# CONSTRUCTION PLANS FOR THE HILLS AT LORSON RANCH FILING NO. 3

## STREET & STORM SEWER CONSTRUCTION PLANS

**THE RIDGE AT LORSON RANCH FIL NO. 3  
STREET & STORM SEWER  
CONSTRUCTION PLANS**

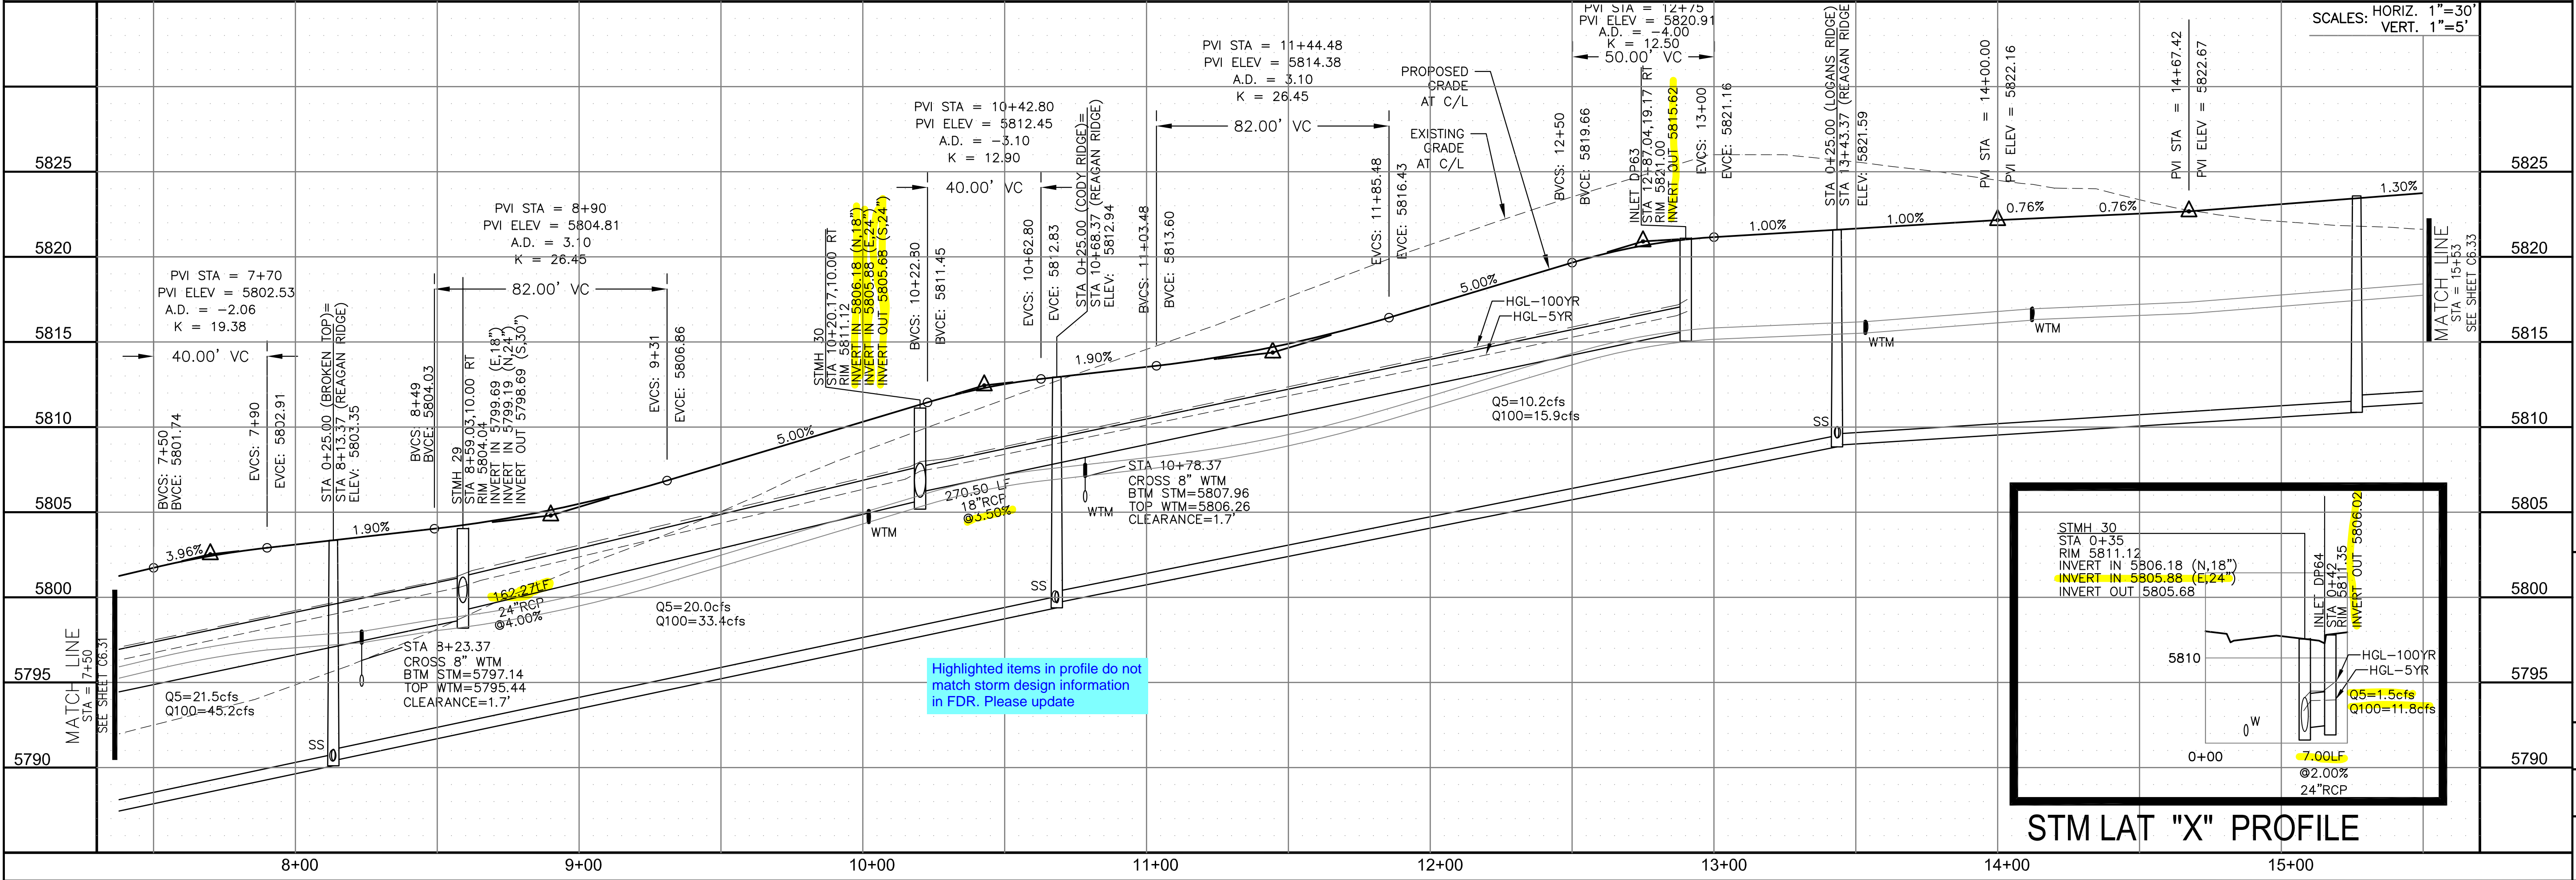
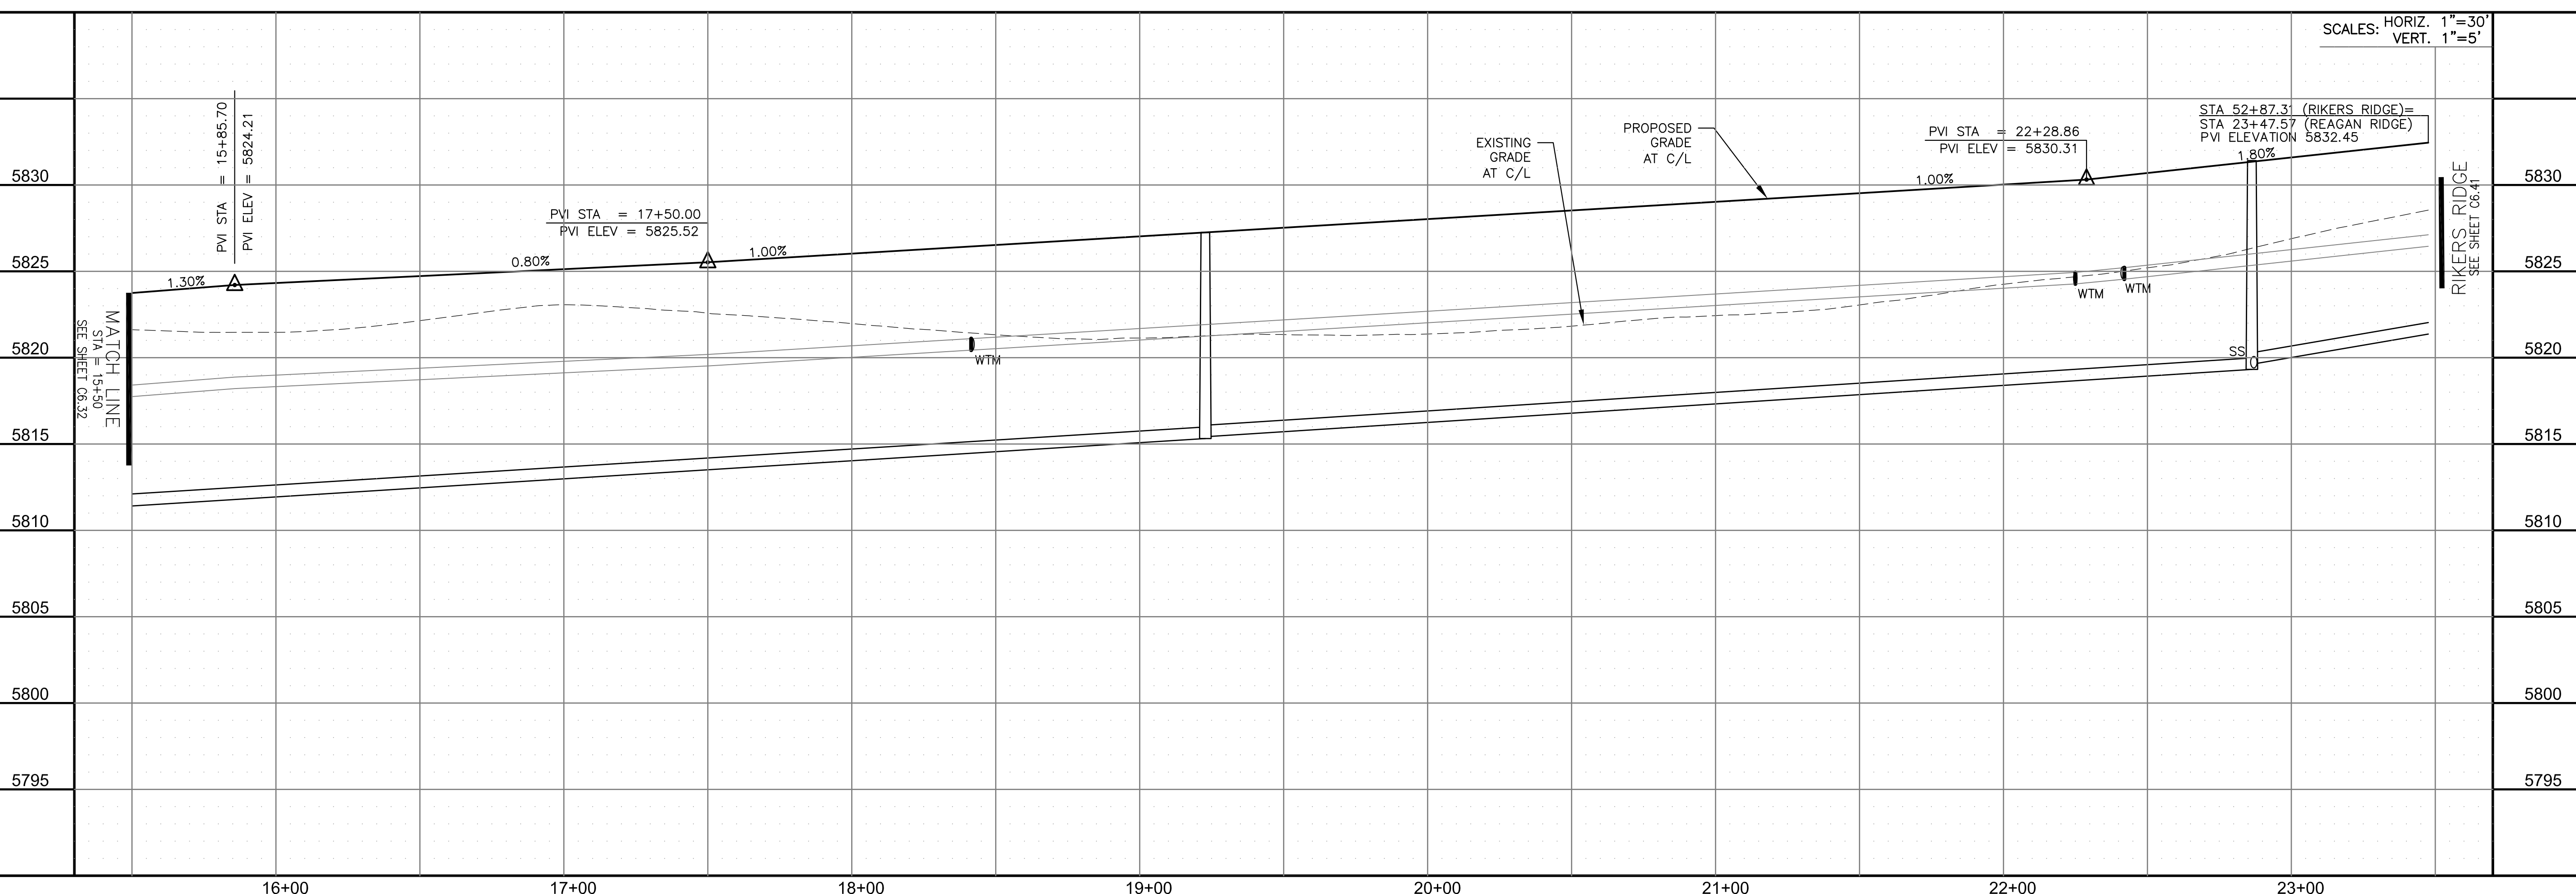
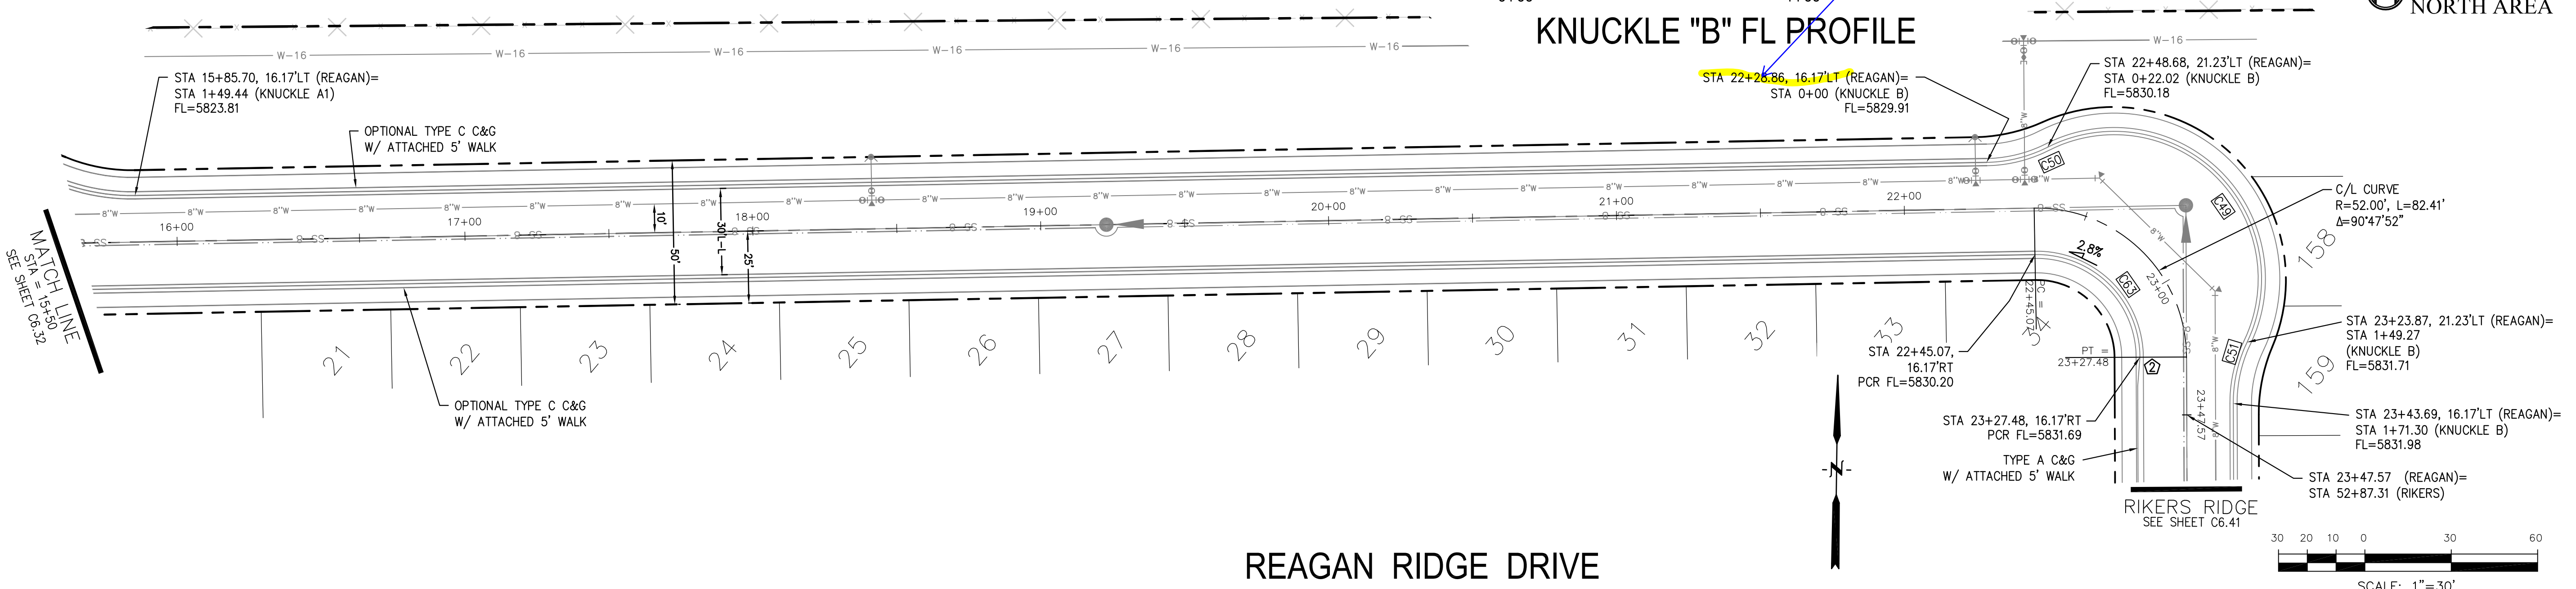
Update all storm profiles to match information shown in Final Drainage Report
